AQUIND INTERCONNECTOR

First Written Question Responses – Appendix 8 Landscape and Visual Correspondance

Document Ref: 7.4.1.8

From: Boden, Maritta
Sent: 24 October 2018 19:00
To: 'Ruth Childs'; [REDACTED]@winchester.gov.uk';
[REDACTED]@havant.gov.uk'; 'Hannah Chapman'
Cc: [REDACTED]
Subject: RE: Aquind - LIVA briefing meeting

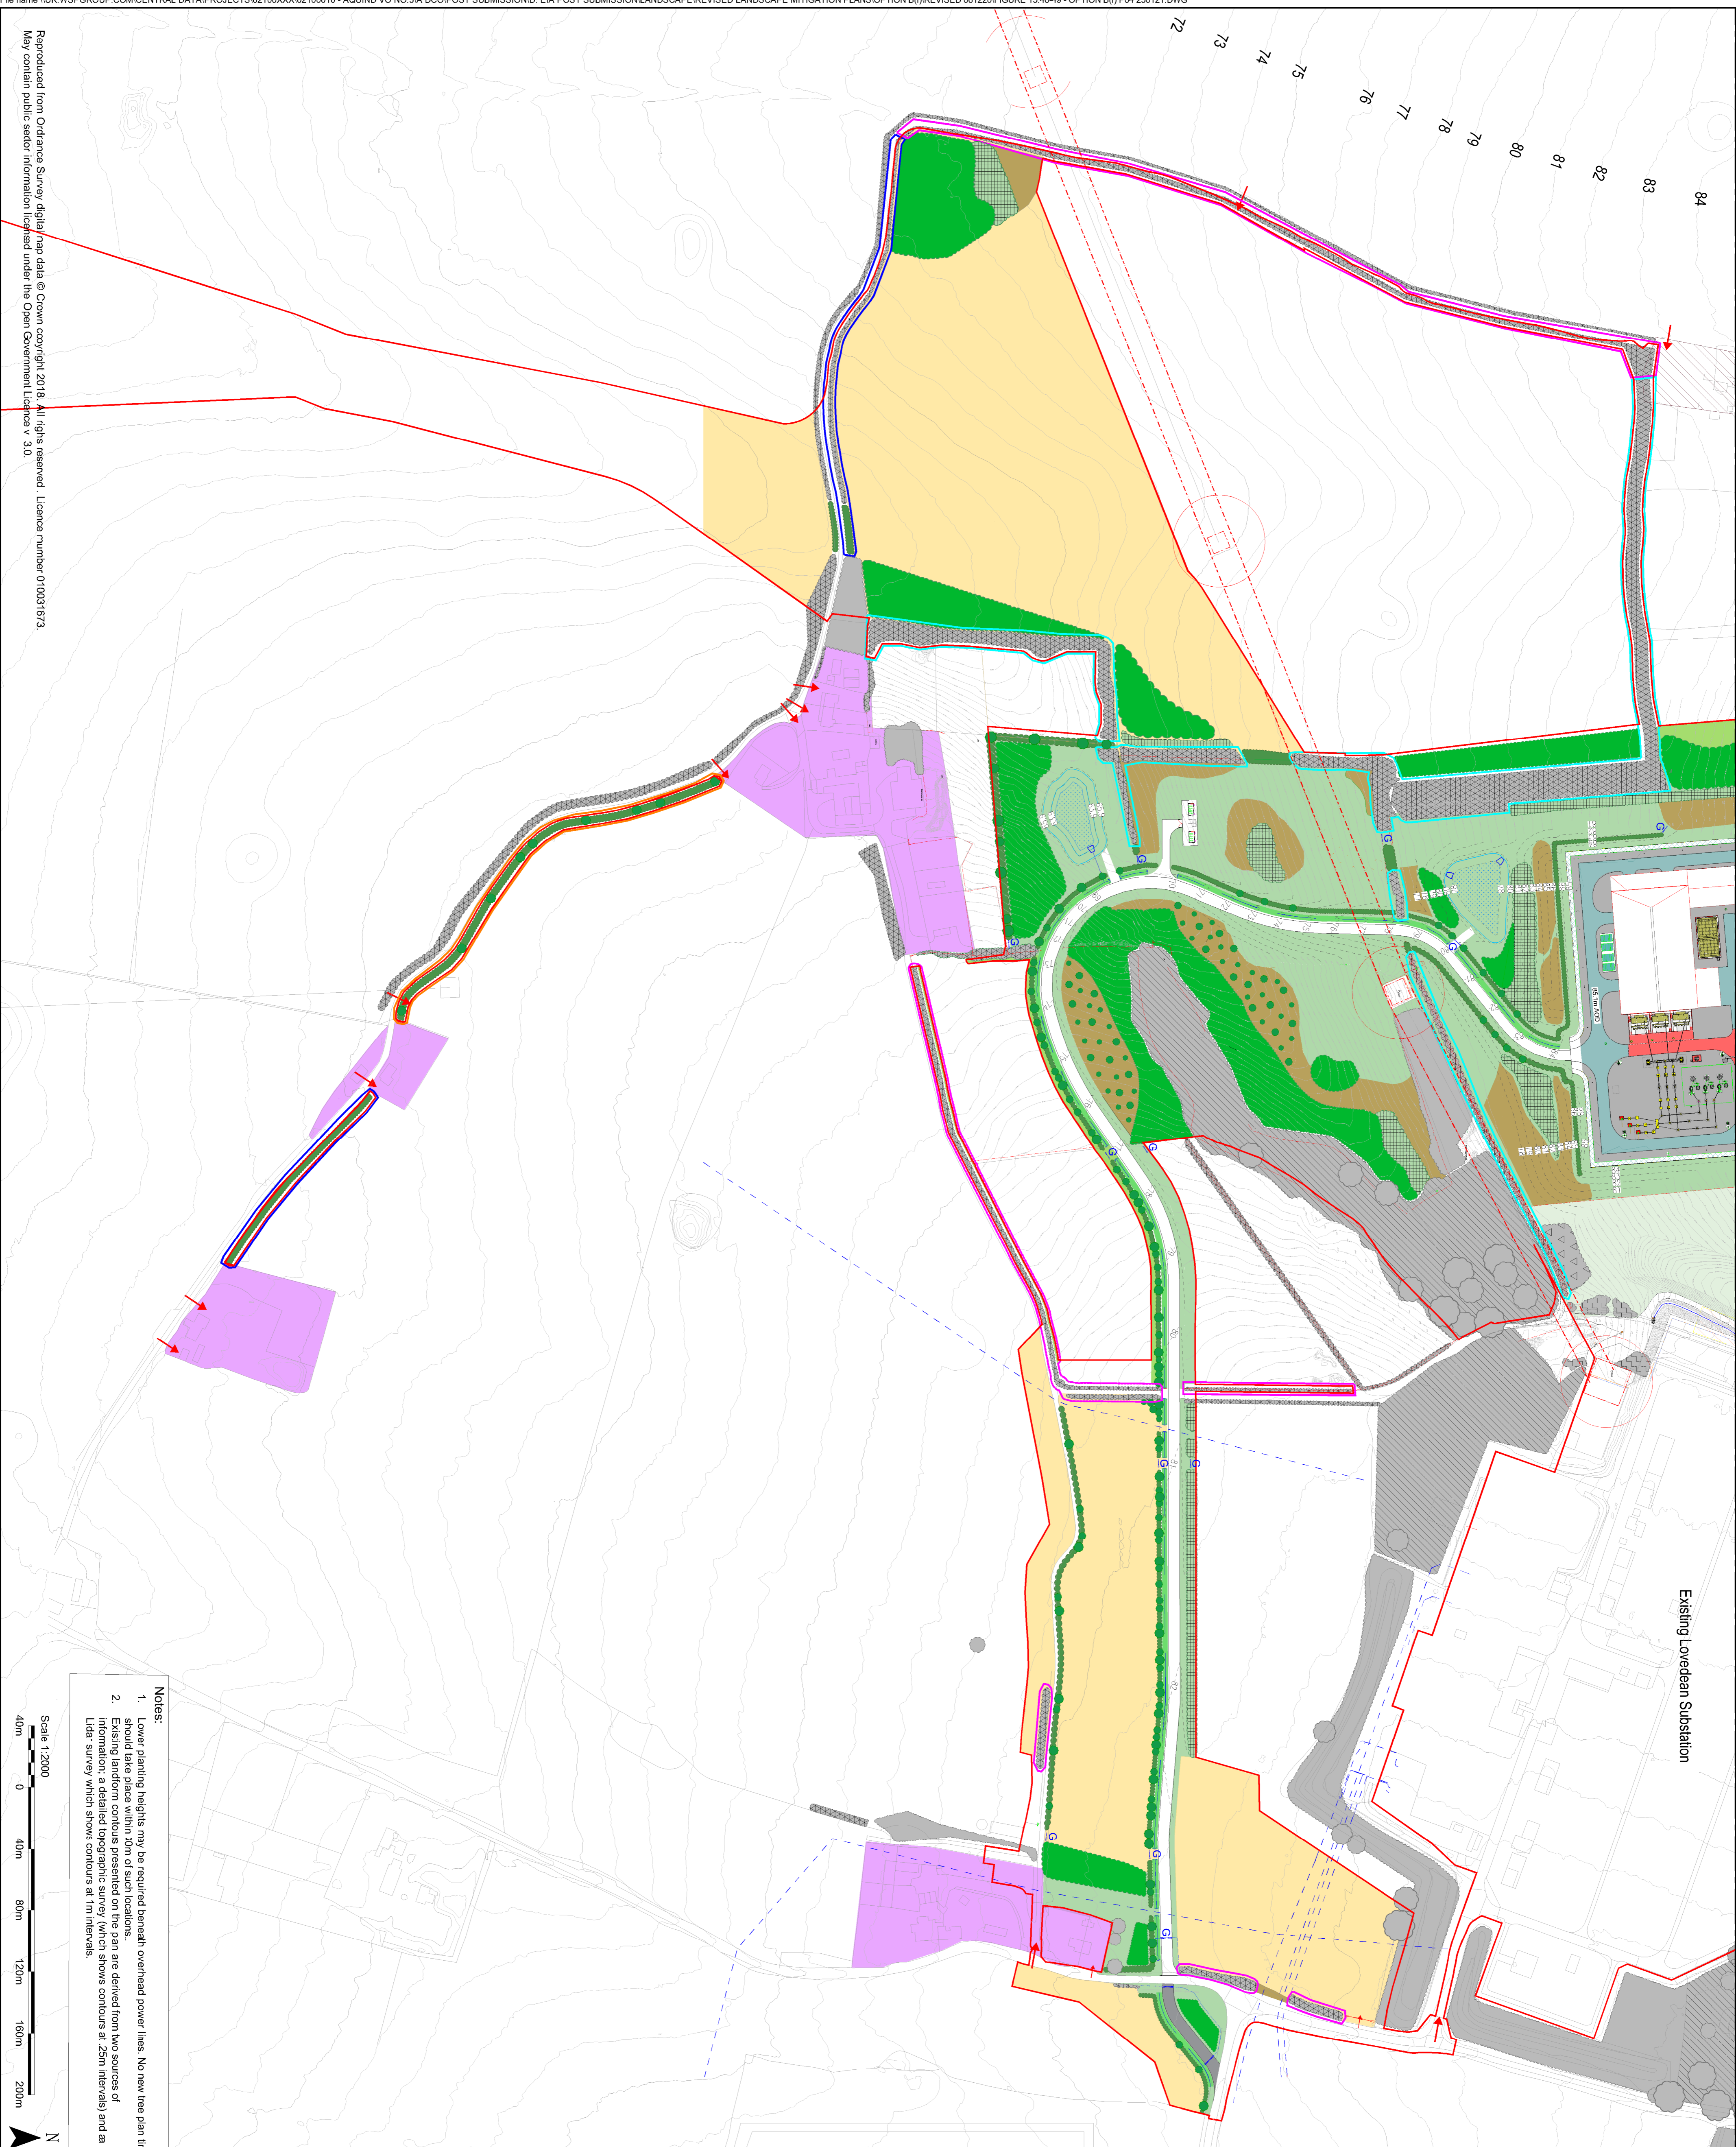
- Whilst, as stated above, the planting 'blobs' both on and off bunds may protect the views, what is the cost? In my view these bunds and planted areas are both highly incongruous in their own right – there are no other elements like this in this landscape. Instead perhaps consider what the inherited vegetation pattern is. How can this be used to deliver *appropriate* mitigation measures to both prevent significant views of the building and conserve/respond to landscape character, and deliver long-term biodiversity and landscape condition improvements?

- The mitigation proposals for Option B also serve to reinforce the building not to hide it. The bund and subsequent planting follows the building line and in my view accentuates it.

- I do not support the use of bunds. They generate an engineered character incongruous in what remains an agricultural landscape.

Your comments on mitigation are very helpful and we entirely agree with the need to retain where possible the existing vegetation. We are therefore in the process of reviewing the cut and fill particularly for Option B to determine whether, whilst maintaining a cut of approximately 5m at the northern end of the converter station, fill can be used to soften the slope to the south rather creating surrounding mounds.

Again we are at a very early stage in developing the design but we have reviewed the mitigation plans and revised them to improve connectivity with existing features including the ancient woodland. We have also introduced additional features, reinstating historic boundaries and copses where possible, provided further visual screening and replicated the surrounding landscape character. Once approved we hope we can share these revised plans with all of you.
